Our Ref: WS010005

Application by Augean South Limited for an Order Granting Development Consent for the East Northants Resource Management Facility Western Extension

Advice following issue of decision not to accept the application for examination

Land Plan

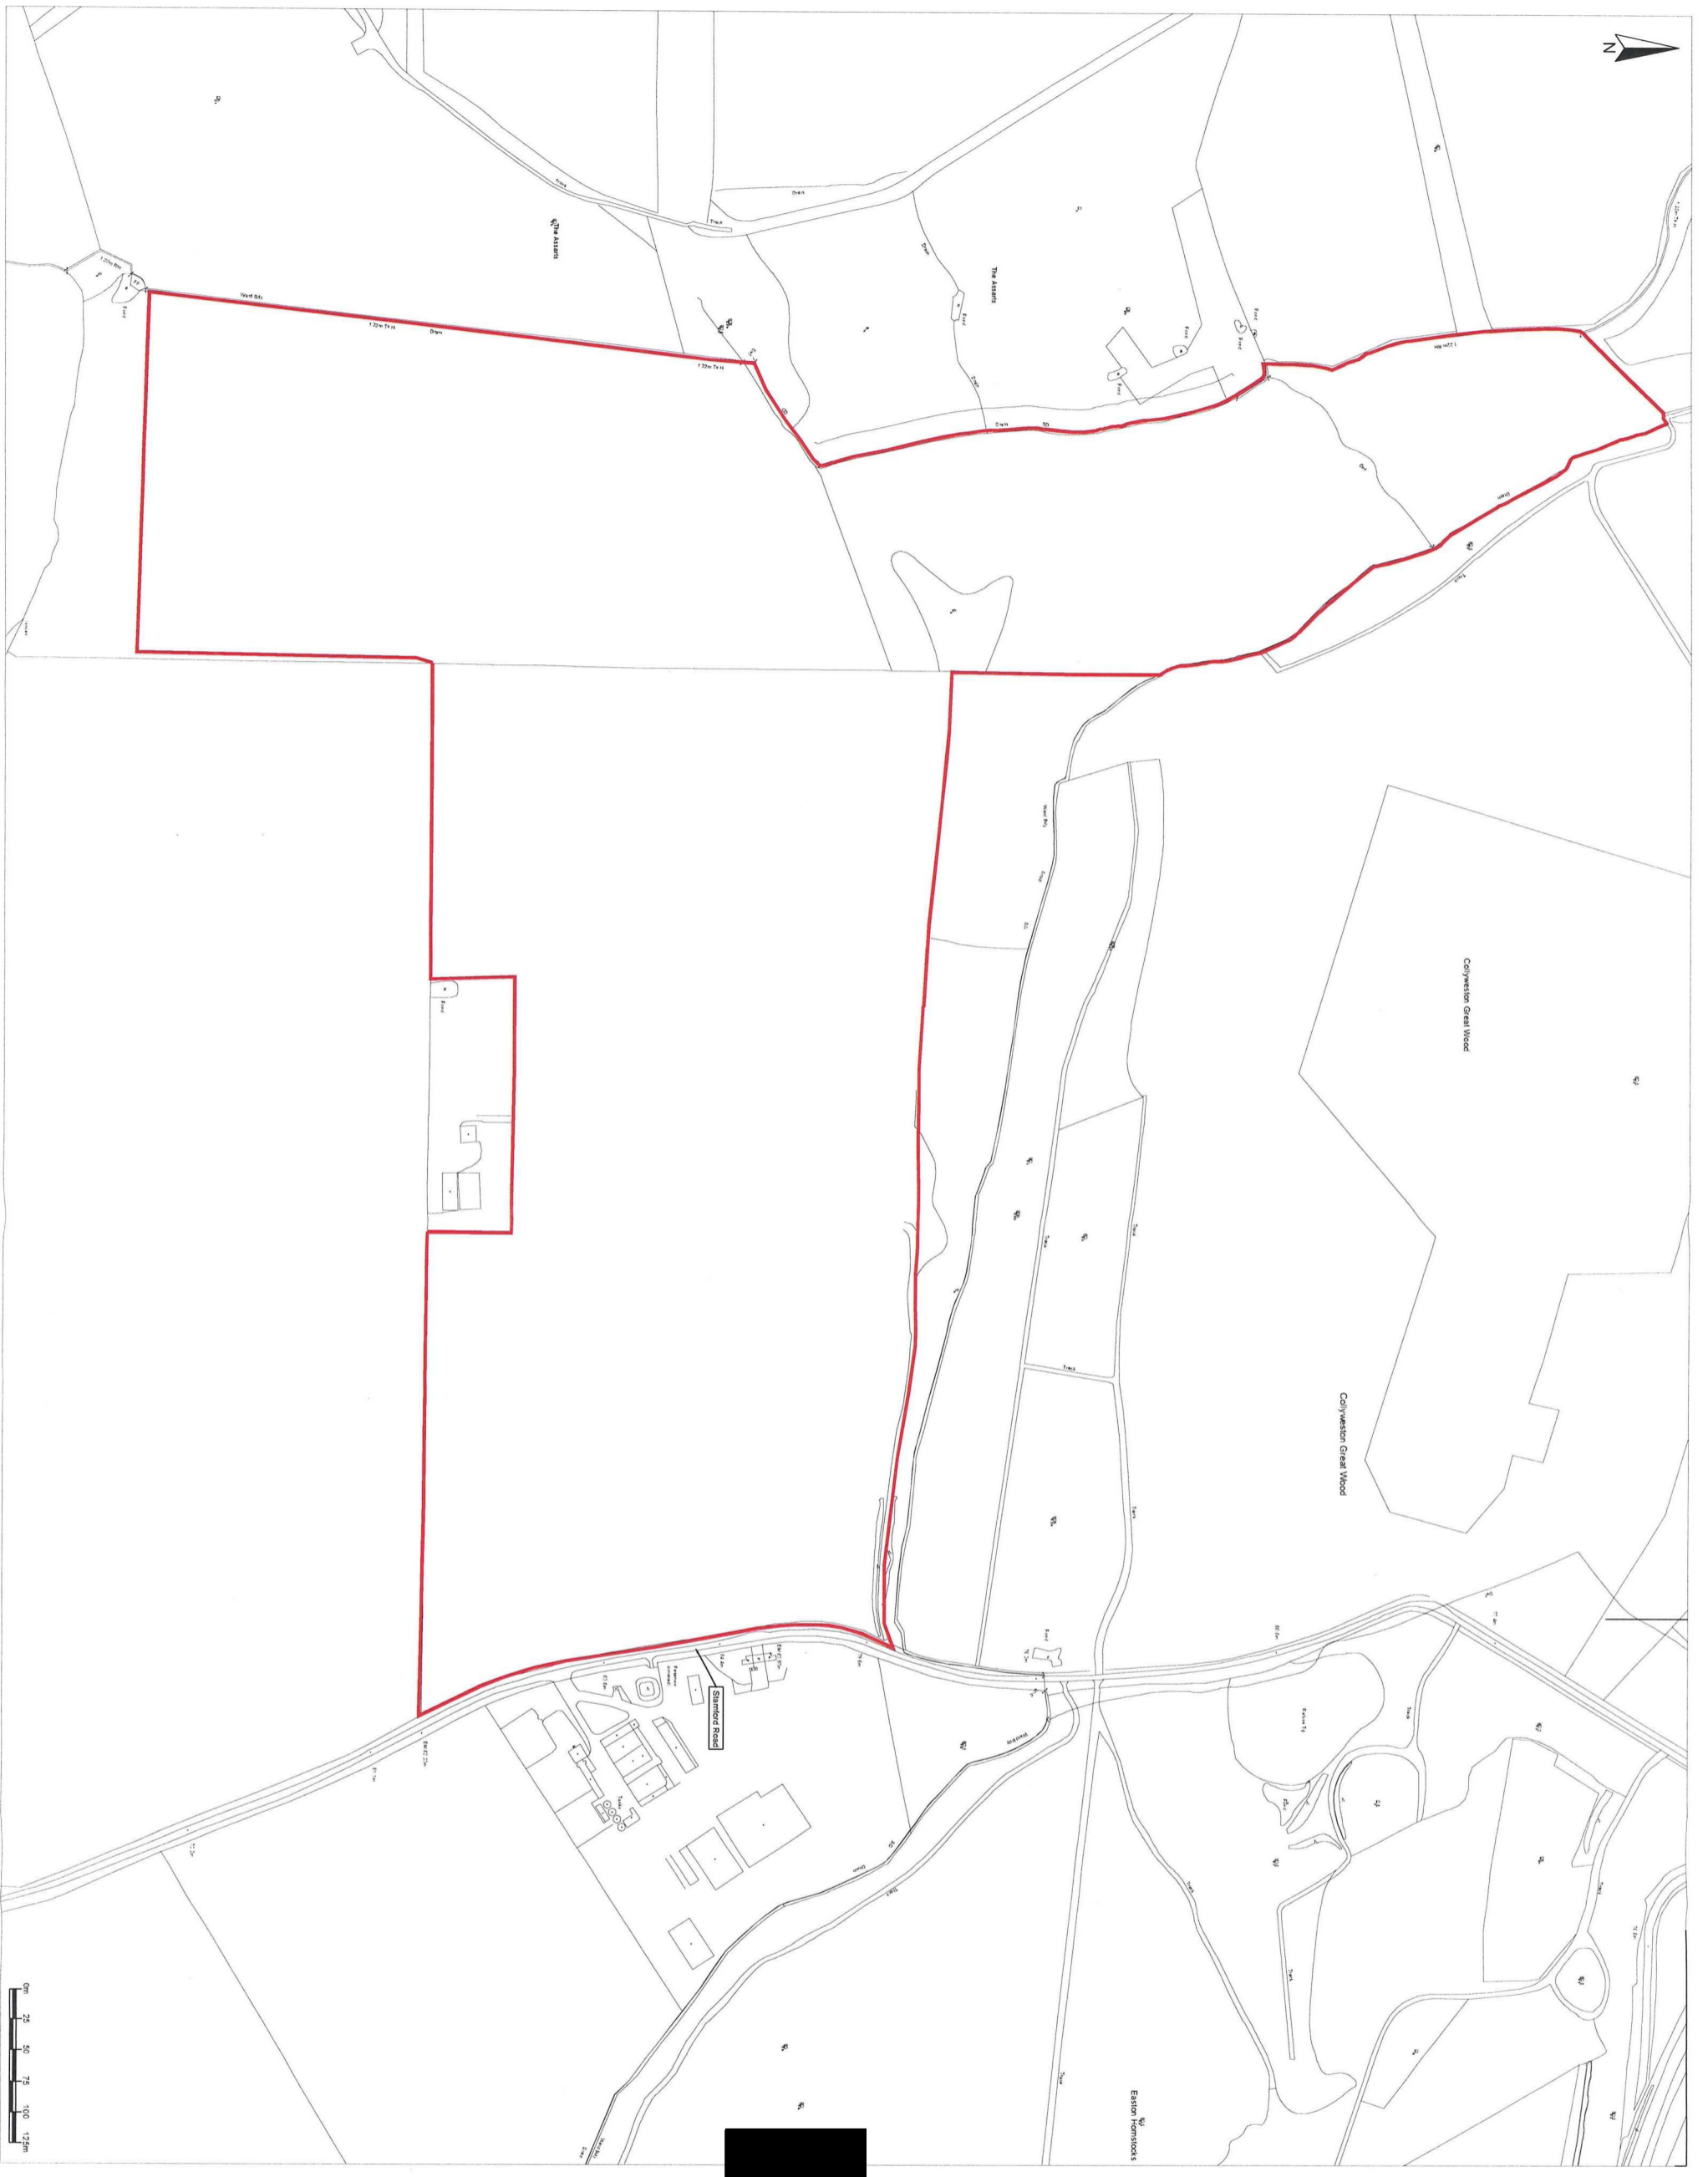
A Land Plan was submitted as part of the application. However, it is not considered by the Inspectorate to be compliant with APFP Regulation 5(2)(i) or a relevant plan in accordance with Annex D, of the DCLG Guidance related to Compulsory Acquisition. It is ambiguous in that it does not clearly show the plots of land required for, or affected by, the proposed development.

A small area on the southern boundary of the site (immediately to the east of the inset area) is not shown as being covered by freehold or leasehold interests. In other places, hatching showing land interests on the Land plan does not align with the Order land boundary. At the most eastern part of the site (the existing facility) land is held by the applicant as both freehold and leasehold.
